Recommendation Report for Planning Permission for Works or Extension to a Dwelling

REF NO: FP/188/18/HH

LOCATION: 68 Limmer Lane
Felpham
PO22 7HE

PROPOSAL: First floor extension including removing fire place & chimney stacks.

Drawing 3 / 4

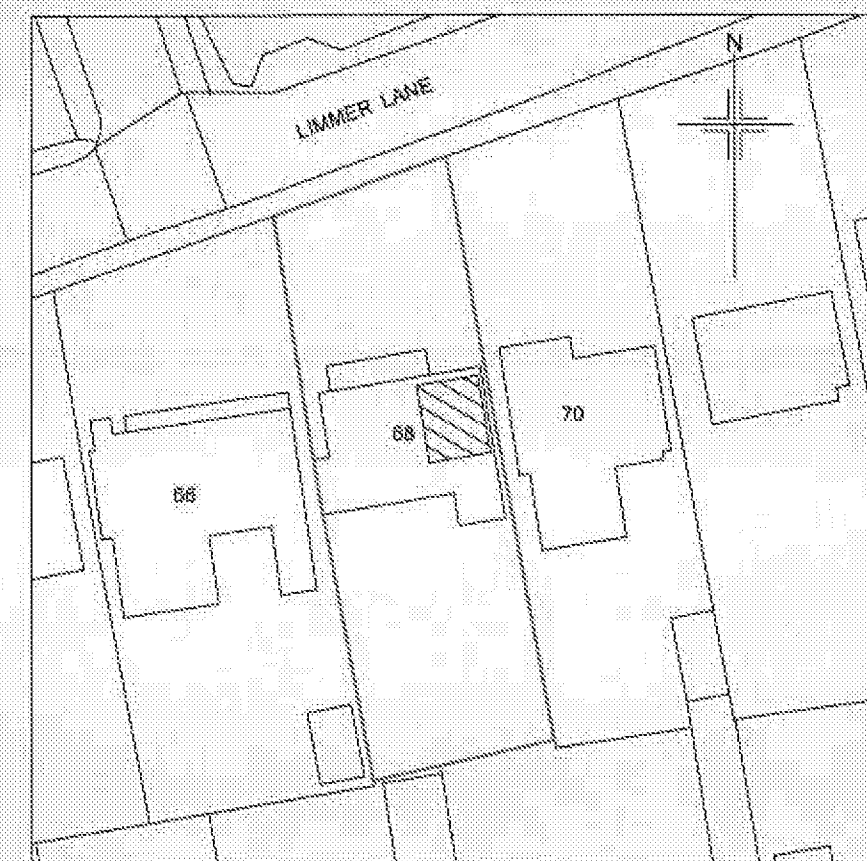
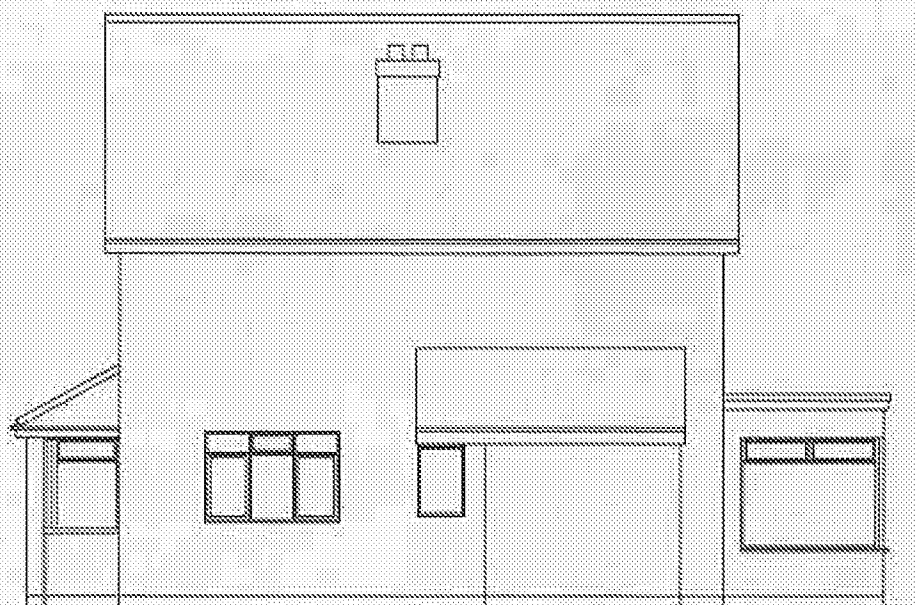
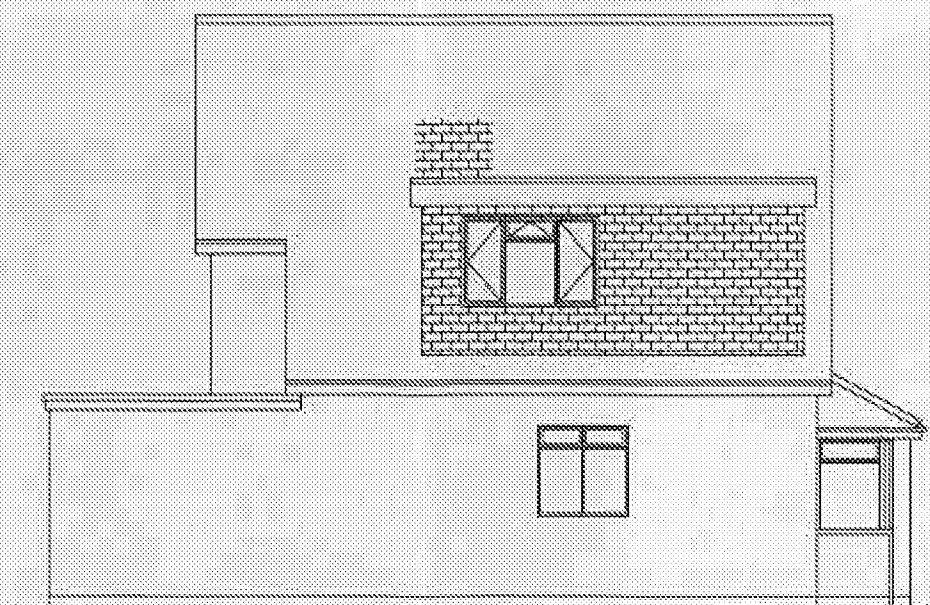
No objection subject to the extension being set back 1 metre from the side boundary.

The proposed box dormer is set back 0.6 metres from the eaves of the dwellinghouse which has a side elevation set back 0.5 metres from the boundary such that the development would be set back 1.1 metres from the side boundary.

The proposed box dormer would not cause a significant loss of light or overbearing impact on the only neighbouring property affected, 70 Limmer Lane as there are no primary habitable room windows on the side elevation of the neighbouring bungalow at ground floor level or in the roof.

The side facing window of the proposed box dormer would not cause a loss of privacy as it would look out over the roof of the neighbouring bungalow and would not have any direct views toward the neighbours rear amenity space over and above the oblique views that already exist at first floor level in the rear elevation of the applicant's property.
